REPORT UPDATE

Application No: FG/6/20/PL

REF NO: FG/6/20/PL

LOCATION: Hangleton Farm Livery Stables
Wadars Animal Rescue Centre
Hangleton Lane
Ferring

WILDLIFE REHABILITATION UNIT
Floor Plan 1:100

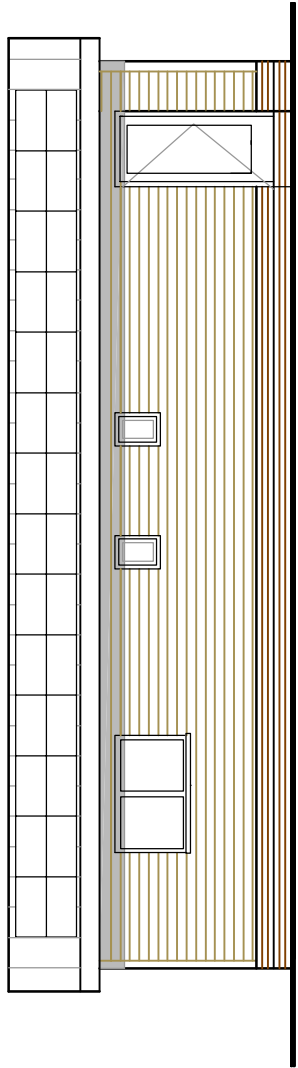
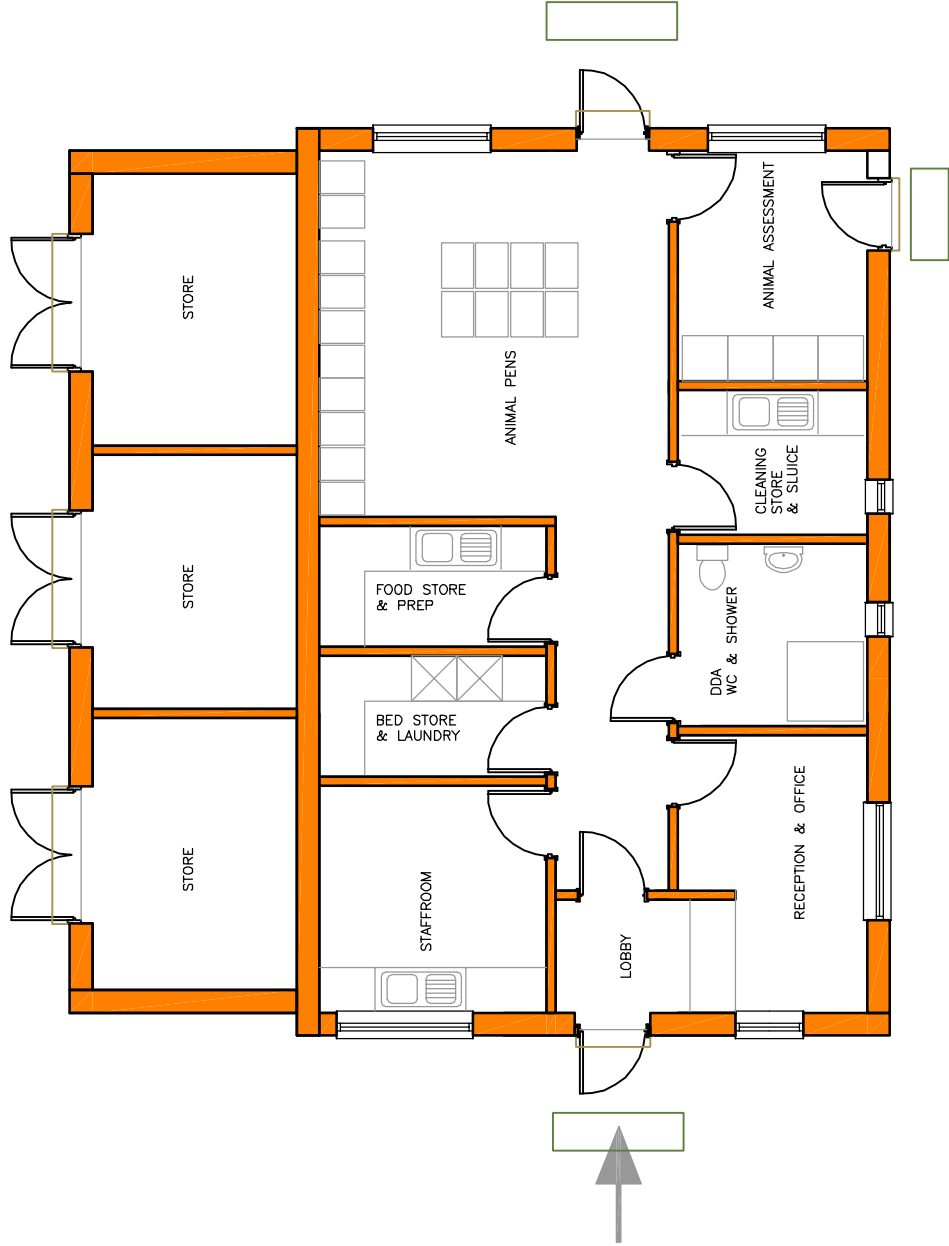
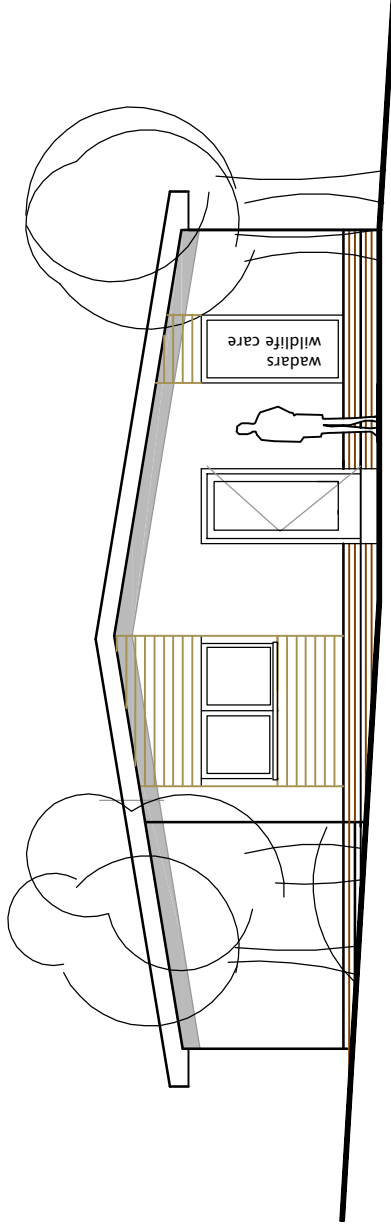
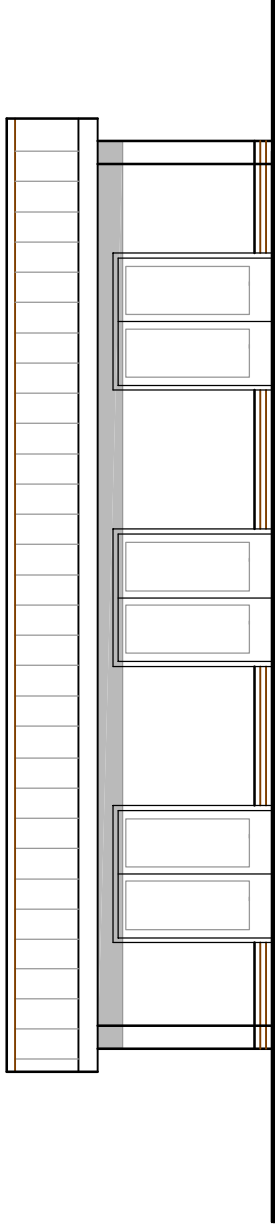
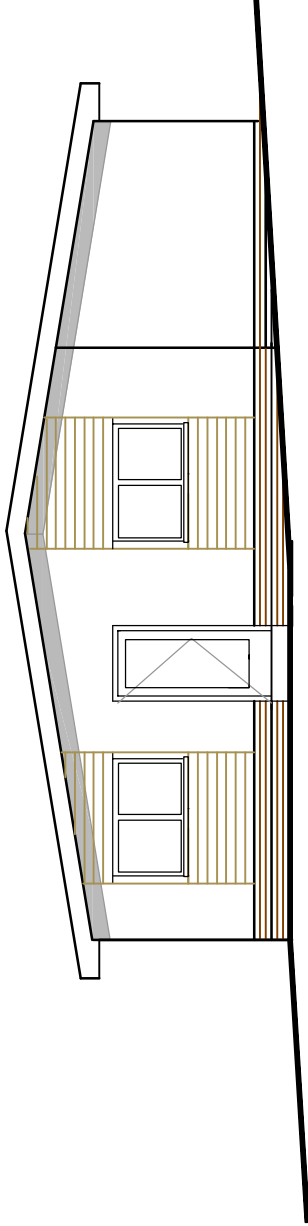
No objection - Concern that the built development extends too far east (particularly wildlife rehabilitation unit) and that the scheme would better be accompanied by a robust landscape-led planting scheme that enhances what is currently a very degraded landscape.

Given the location and size of the wildlife building it is not considered to have an adverse impact on the immediate area given the number of similarly sized buildings in the area where it is proposed to be sited. The recommendation already includes a lighting condition.
